Re: Status of Improvement Permit Application #05-5-13137

On October 5, 2005, an Environmental Health Specialist from the Harnett County Health Department attempted to evaluate your property for the purpose of issuing an Improvement Permit. This individual was unable to evaluate your property for one or more of the following reasons.

Lot 26 - Colonial Hill

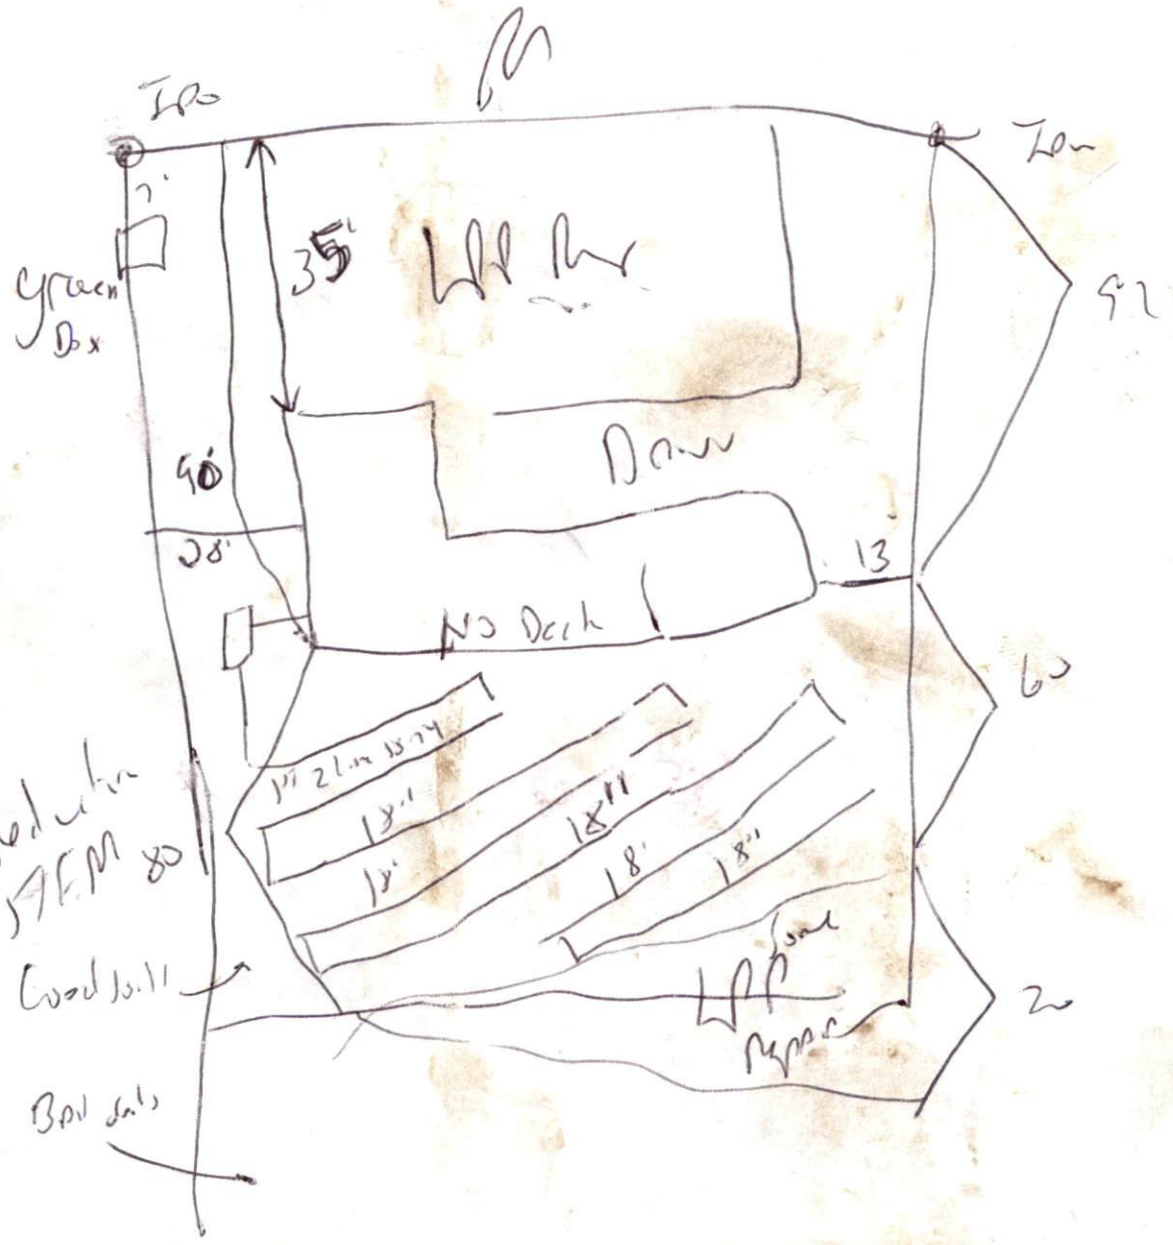
- 1. Property lines/corners not marked or labeled
- 2. House corners not marked or labeled
- 3. Directions not clear to property
- 4. Property needs brush or vegetation removed
- 5. Backhoe pits required
- 6. Other **Change home to these new set backs and submit new plot plan to Central Permitting.**

Please move house to these new setbacks - 9' water
